Development Facilitation Team (DFT) – Review Comments

Project No: PR-2023-008906 Date: 09/27/2023 Agenda Item: #7 Zone Atlas Page: H-16

Legal Description: Tracts 1 & 2 Jones Industrial Park

Application For: SD-2023-00168-Preliminary/Final Plat (DHO)

SKETCH PLAT FOR
 LOT 1-A
 JONES INDUSTRIAL PARK
 SITUATE WITHIN
 SECTION 10, T. 10 N., R. 3 E., N.M.P.M.
 CITY OF ALBUQUERQUE
 BERNALILLO COUNTY, NEW MEXICO
 JUNE 2023

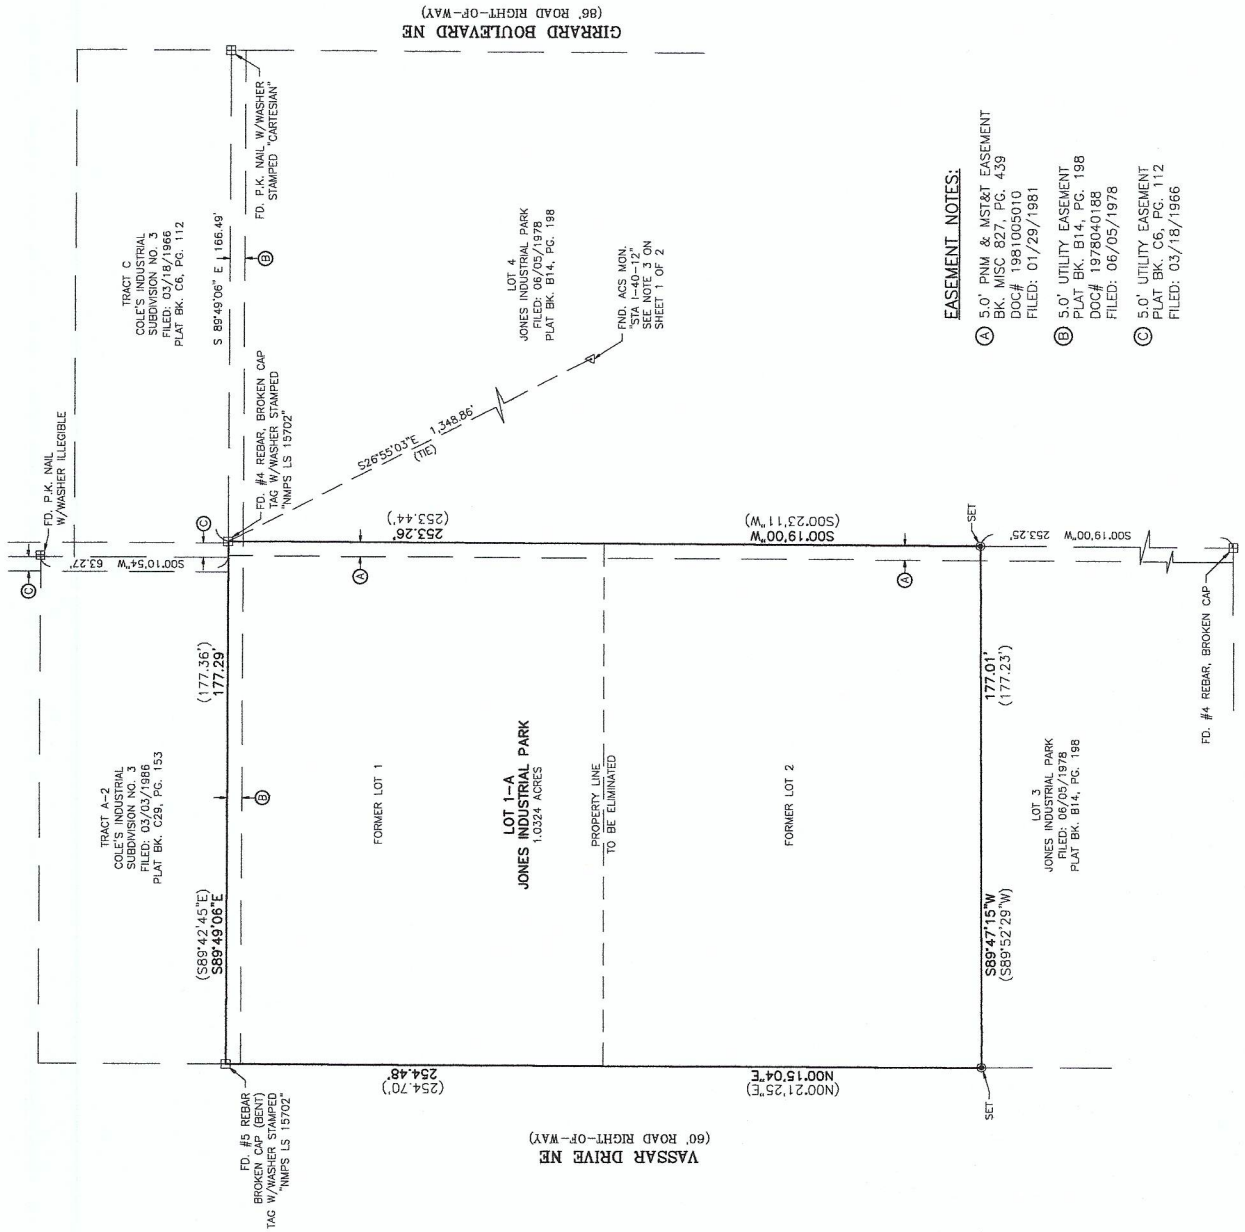
1. Vasser is a local street and requires 5' sidewalk with a 4-6' landscape buffer. Your updated sidewalk exhibit shows a 3.9' sidewalk. This is below the minimum allowed by ADA. The justification provided is not sufficient and 5' sidewalk needs to be provided.
2. Any future development would require an approved TCL prior to site plan or building permit.

- The applicant is seeking a determination to allow the existing 4' sidewalks along Vassar Dr to remain in lieu of the 5' sidewalk. Applicant was informed in the prior DHO hearing that the 5-foot sidewalk is needed and that with the condition of the existing sidewalk and the need to close driveways and account for ADA compliance, that this is a new 5 foot sidewalk is the recommended approach.
- Property is within the Menaul & University Landfill Buffer. Development will require Environmental Health approval. Please add the following note regarding this item to the title/cover page of the plat:

- Demonstrate compliance with **section 7 of the DPM Table 7.2.29** and Required Improvements section from 5-4(N) of the IDO. In regards to the Sidewalk width requirements and the accompanying landscape buffer.
Verification of standards per Transportation
Provide measurement for the existing ROW and distance from curb to property line along street frontages.

- Vassar is a local street. Not in a Center or Corridor area.
Requires a 5ft side walk and 4-6ft landscape buffer. **Please clarify buffer zone along the sidewalk and street trees.**

- The subject site currently has two curb cuts and the applicant intends on removing them and replacing them at different locations. Sidewalks, modified curb and gutter will replace the curb and cuts. An infrastructure list has been provided to demonstrate these
